SOILS AND GEOLOGY STUDY

**18885 Brown Road
Lots 1-3, Owl Ridge Subdivision
El Paso County, Colorado**

JOB NO. 185466

**November 15, 2021
Revised: February 21, 2022**

Fig-6

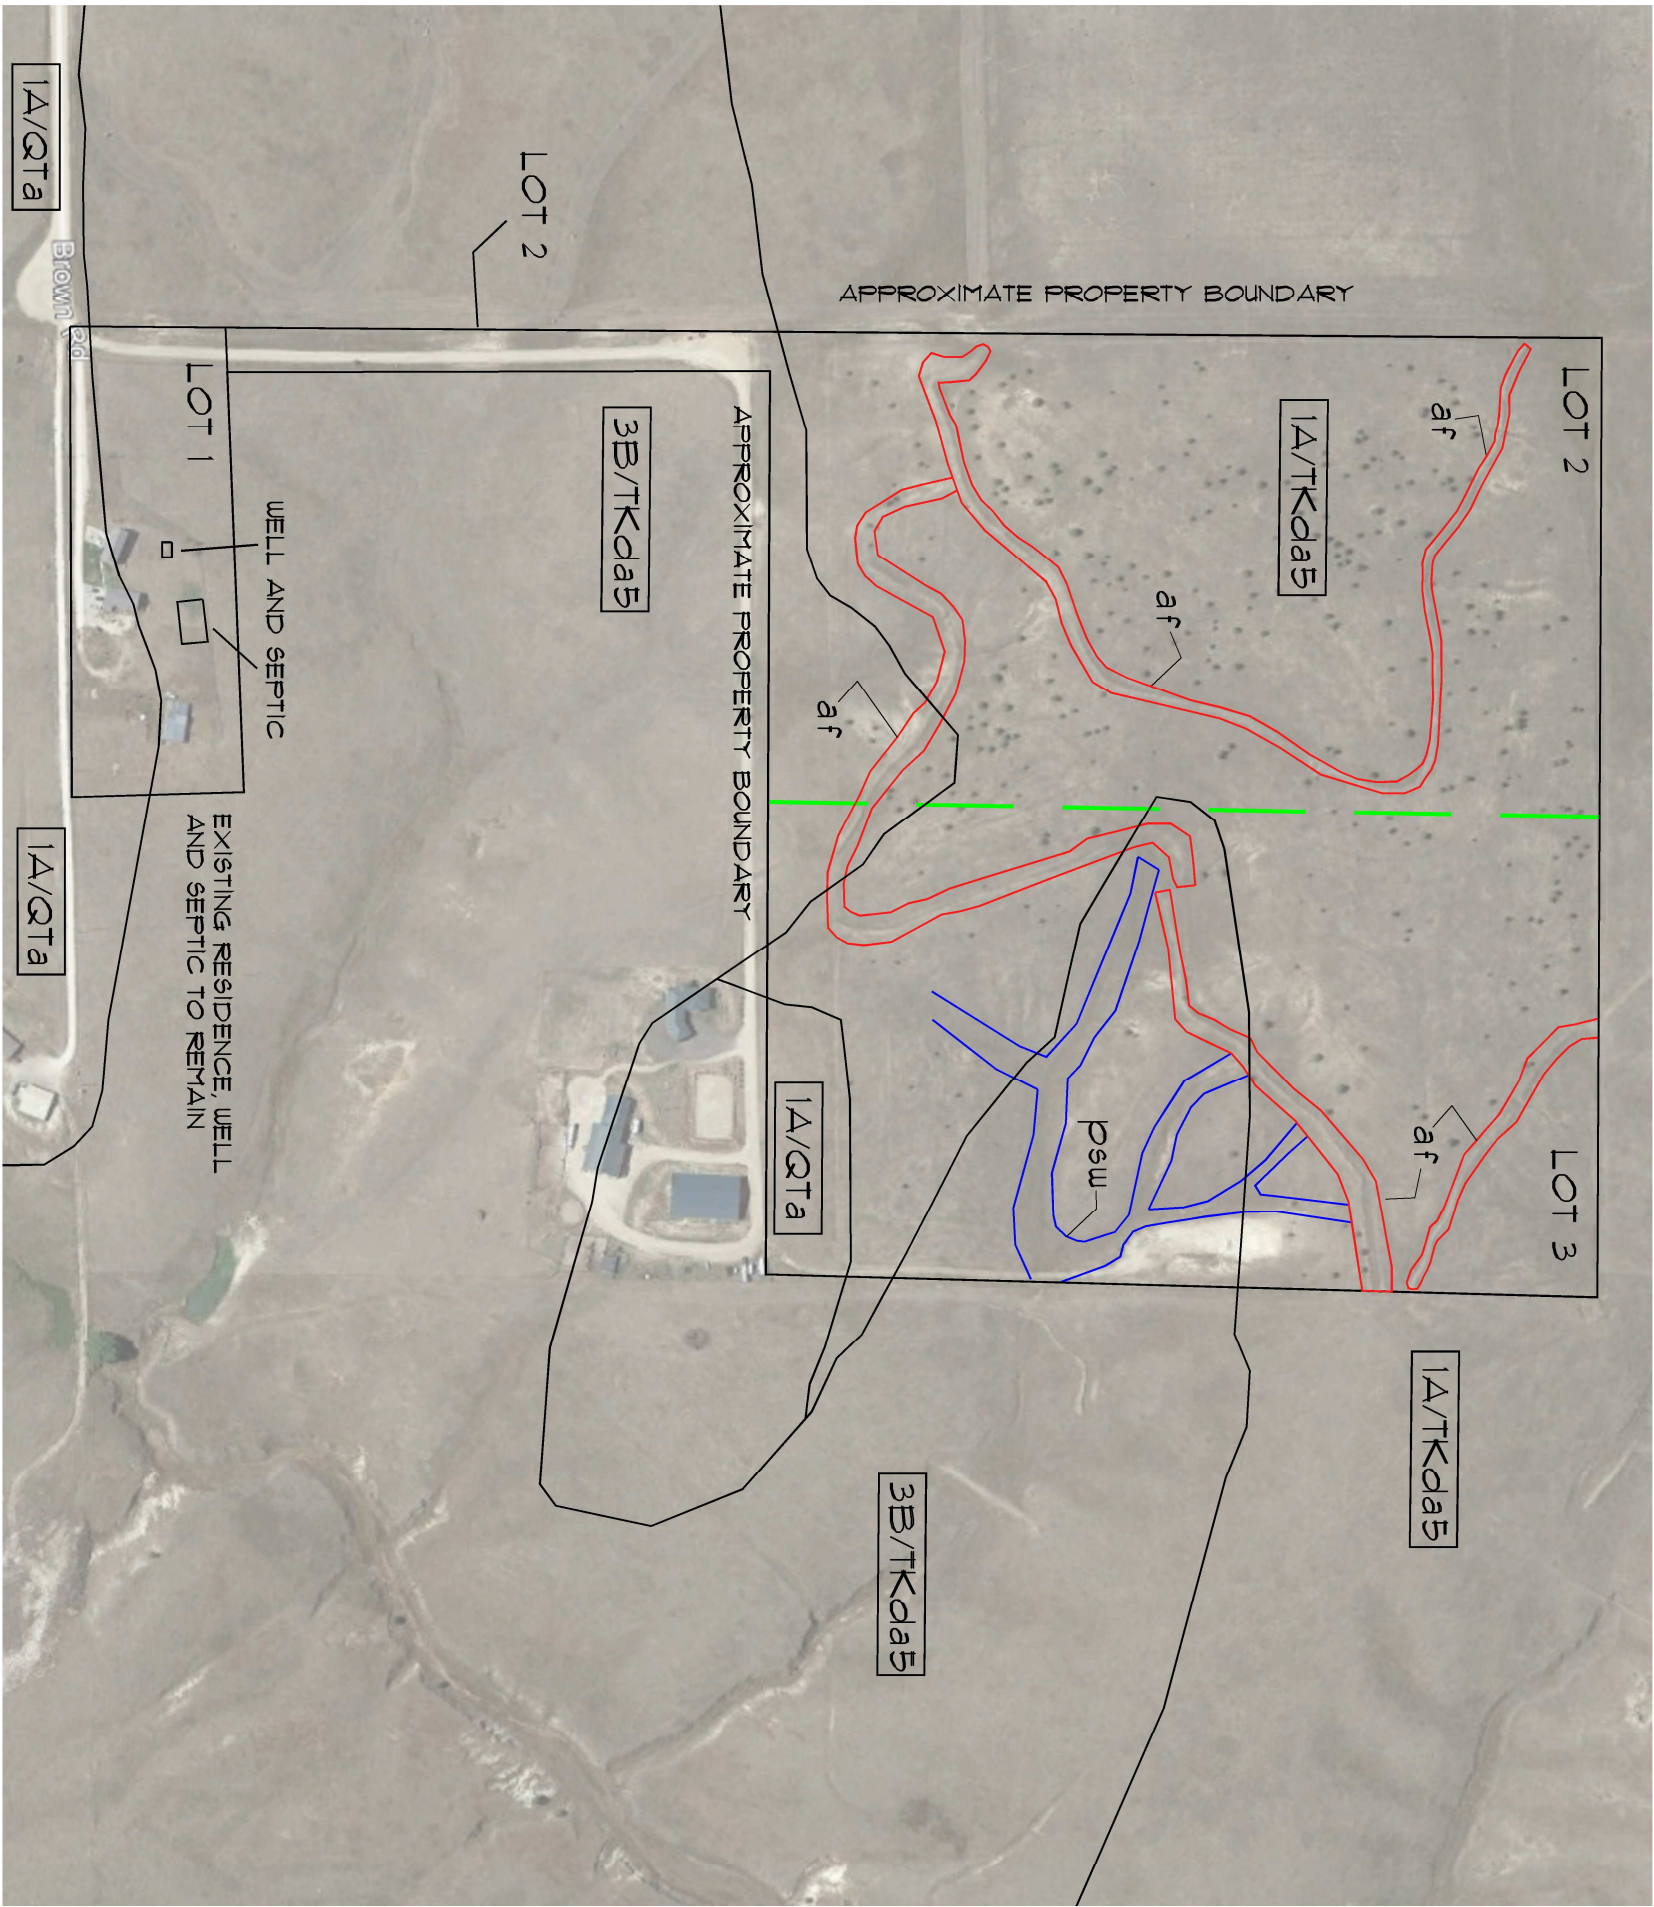
See CGS review comments to be addressed on seasonal wet areas on Fig 4 and expected seasonal groundwater fluctuations etc. The drainage report depicts a proposed building site potentially directly in the area shown as season wet area.
